CITY OF ALBUQUERQUE

Site: Eagle Ranch MVD

Re: Drainage Ordinance (14-5-2-1) Violations for Erosion and Sediment Control and Trash

Inspections Plus Inc.  
Erosion Control Plan  
Standard Details

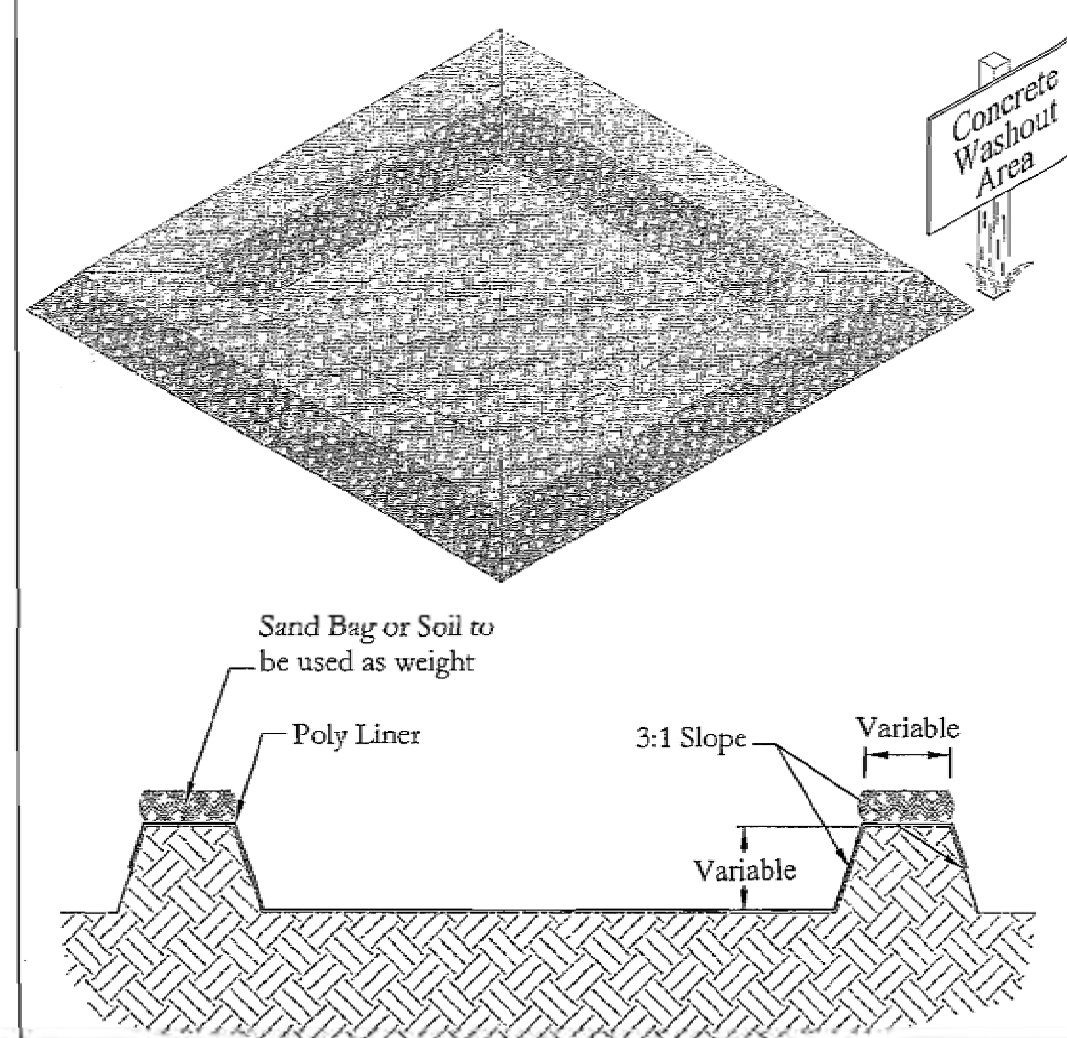
1. No BMP to prevent windblown sediment from leaving the site along the northern edge of the site.
2. Windblown sediment in adjoining property to the north.
3. Trash not in a trash receptacle and trash receptacle not observed onsite.
4. No track-out pad/stabilized construction entrance.
5. No sediment BMP to prevent sediment from leaving the site at the cul-de-sac.

No track-out pad. Also, long and steep area with no sediment BMP.

1. Install a sediment BMP to prevent sediment from leaving the site along the northern edge of the site as shown on the approved ESC plan.
2. Install a trash receptacle and place trash in it.
3. Install a track-out pad/stabilized construction entrance per the detail on the approved ESC plan.
4. The approved plan shows the track-out pad on the south side of the cul-de-sac. This was intentional as there is a long and steep slope up to the Phase 1 building site. If you choose to build the track-out pad on the west side of the cul-de-sac (uphill), then a swale or berm should be built to direct flows away from the track-out pad.
